**Kevin Cox**  
**Crime Prevention Design Advisor**  
Thames Valley Police Headquarters South  
Oxford Road  
Kidlington  
Oxfordshire  
OX5 2NX

**REF: 21/04289/OUT**

**Location: OS Parcel 1570 Adjoining And West Of  
Chilgrove Drive And Adjoining And North Of Camp Road  
Heyford Park**

10 June 2022

Access & Movement Parameter Plan

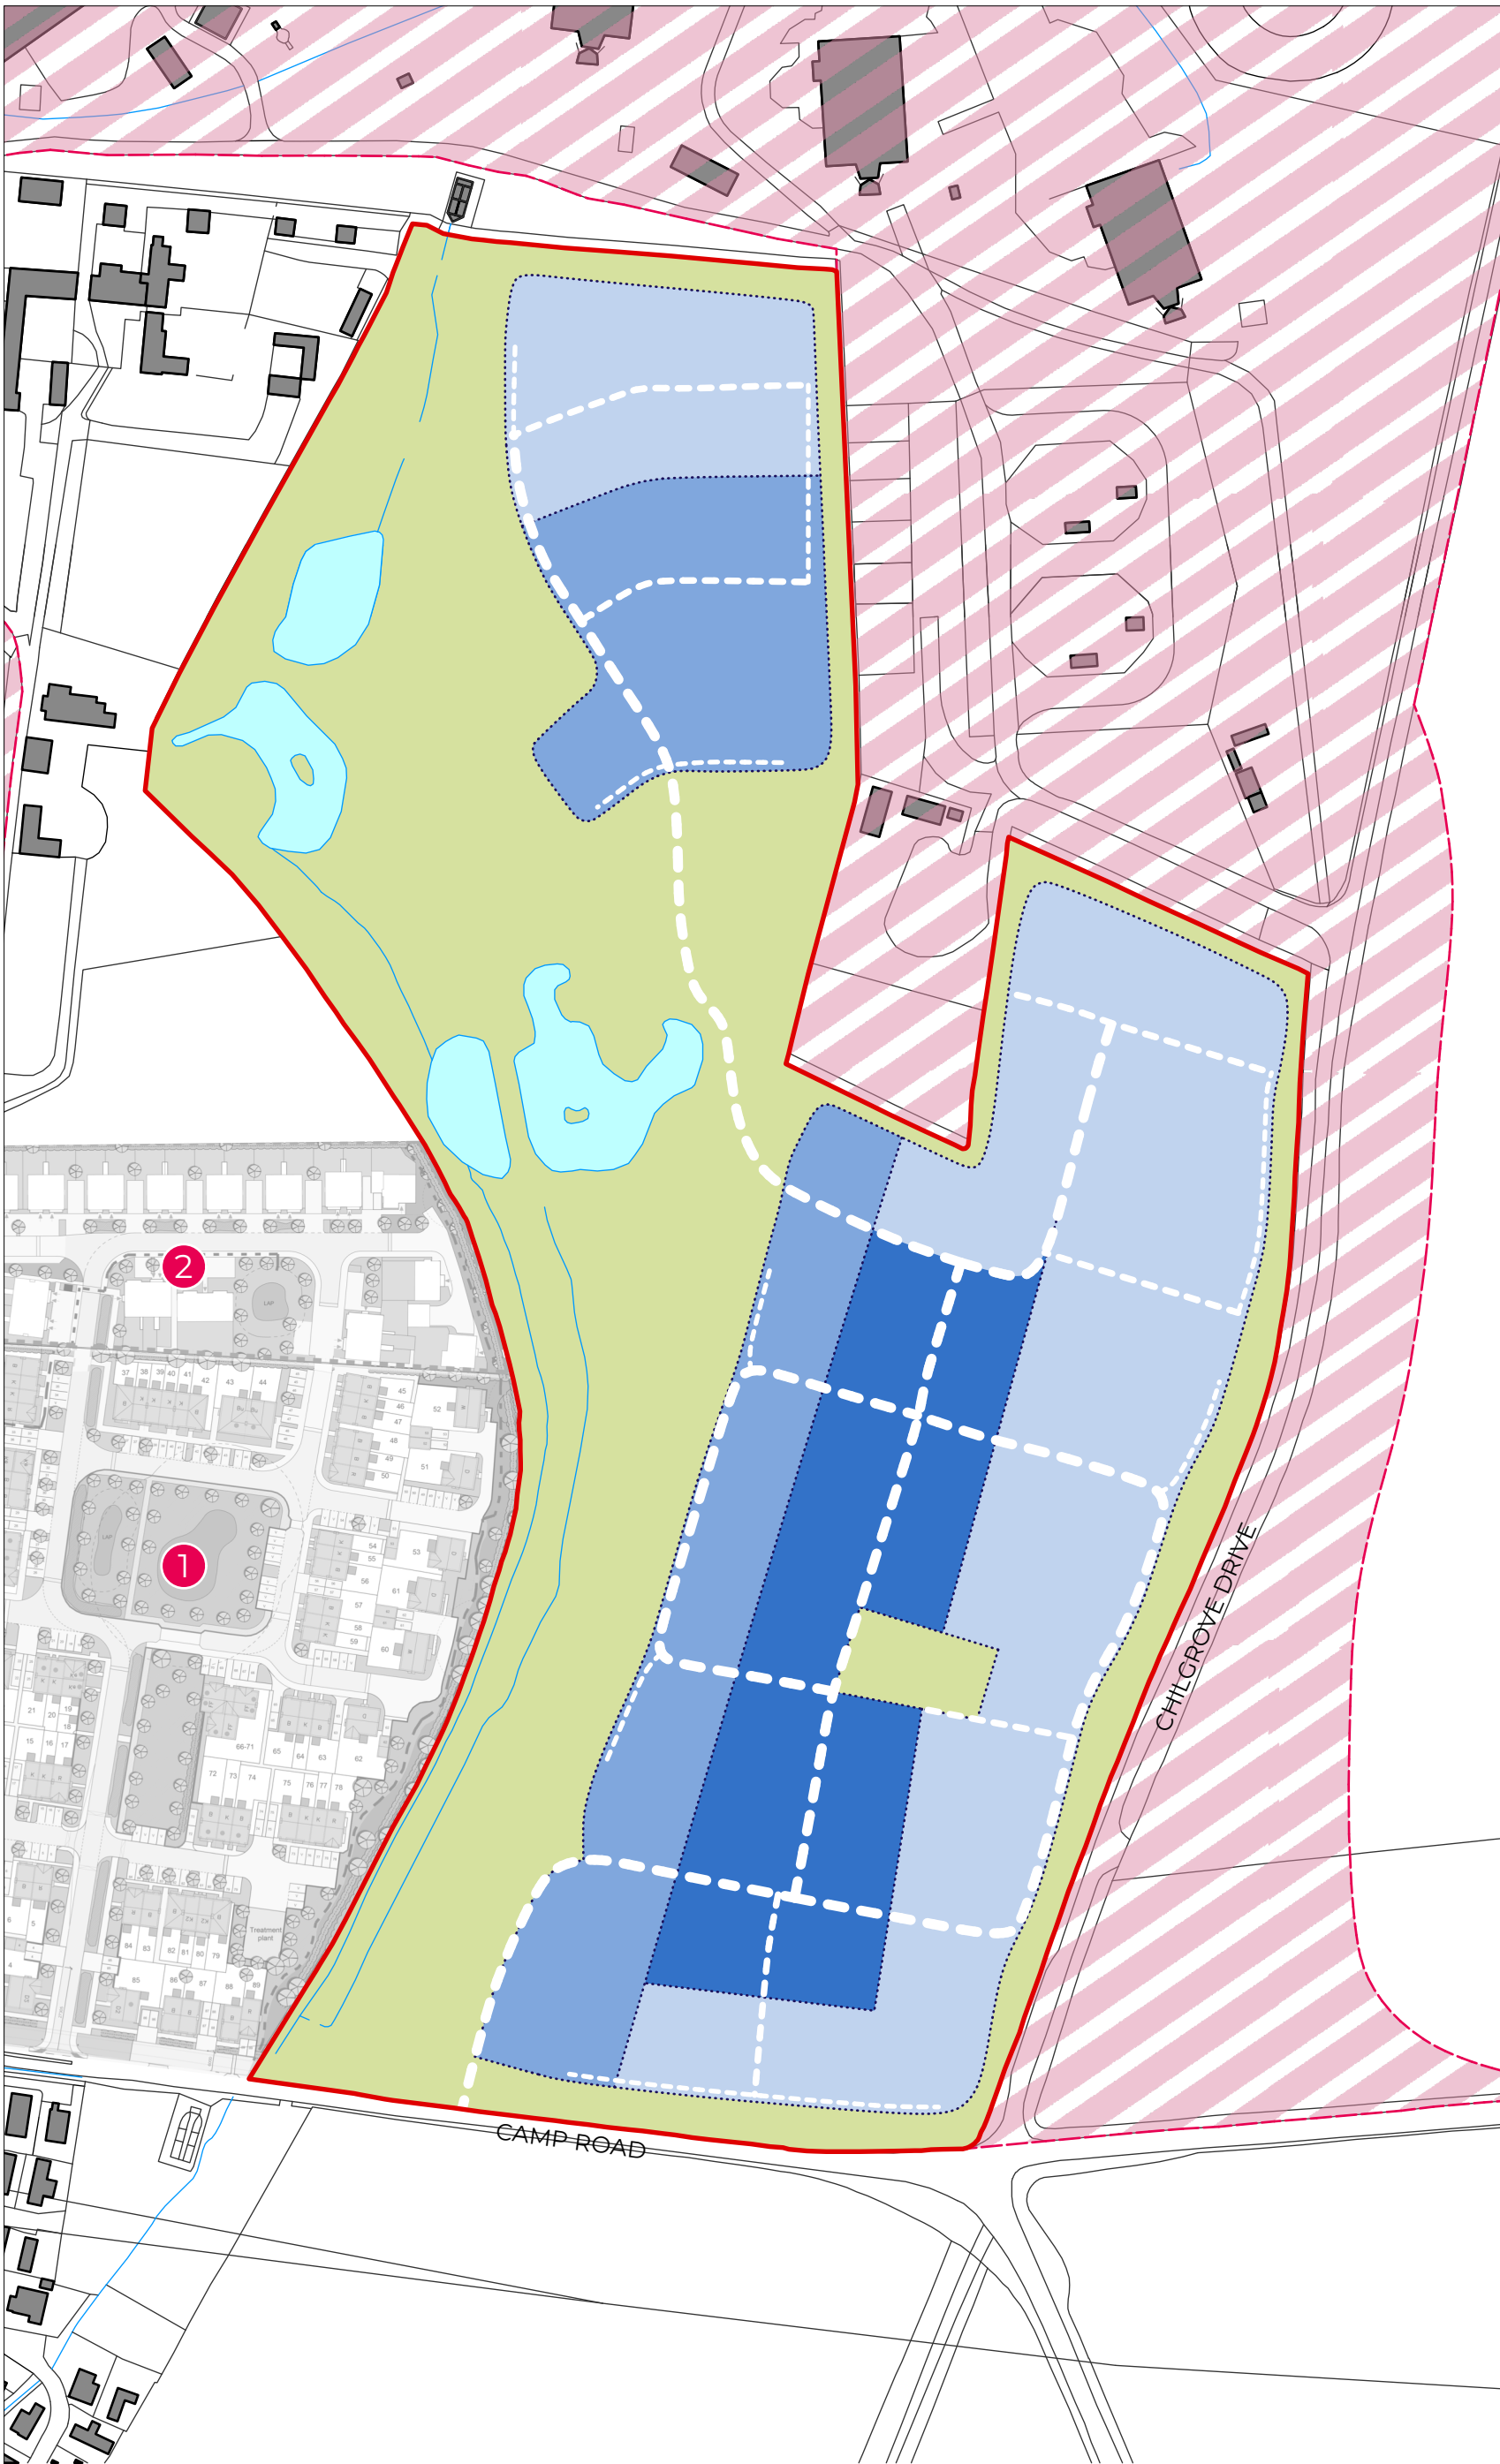
- The primary route through the development is formed primarily with a long, relatively straight section of road. This creates a risk that speeding through the development will easily occur. I recommend ensuring this road is laid out and designed to minimise the risk of speeding, through the use of landscaping, surfacing and deviations in route to reduce the speed of vehicles.

- The secondary street connecting the north and south residential areas will be a primary route for pedestrians and cyclists, and therefore it must be promoted as a safe route with lighting along the entirety of the route, which should conform to BS 5489-1:2020, including sections through green space. Proposed tree planting must take lighting into consideration to avoid areas of pooling and shadowing of light at night which can support and create a fear of crime. Sections of the route leave pedestrians vulnerable to crime and ASB, particularly around the pond area where a bend in the road reduces surveillance. I recommend this route is designed with surveillance in mind, and surrounding vegetation and residential development should be utilised to open up and maximise views over this route from both ends.

- Footpaths through public open space and wetlands, particularly to the west of the development, may be at risk of crime and antisocial behaviour, due to a lack of surveillance from surrounding developments where vegetation prohibits this. It is important that footpaths provide clear sightlines and have a sufficient width to prevent vegetation restricting views for users, and they should be protected by surveillance from surrounding residential development. Footpaths such as these should not be lit at night, to encourage pedestrians to use primary safe routes which are well lit and overlooked.

- The pedestrian connection to camp road at the south-eastern corner of the site (running along the eastern boundary) must be designed with surveillance maximised from surrounding dwellings.

Sections running alongside vulnerable side boundaries of gardens lack surveillance, leaving the boundary vulnerable and reducing surveillance over pedestrians using the link. Building orientation and windows in gable ends should be carefully considered to maximise views over pedestrian/cycle only links such as these. Defensible space and planting to a depth of at least 1m must be provided to side or rear boundaries adjoining public footpaths, as well as to any easily accessible ground floor windows.
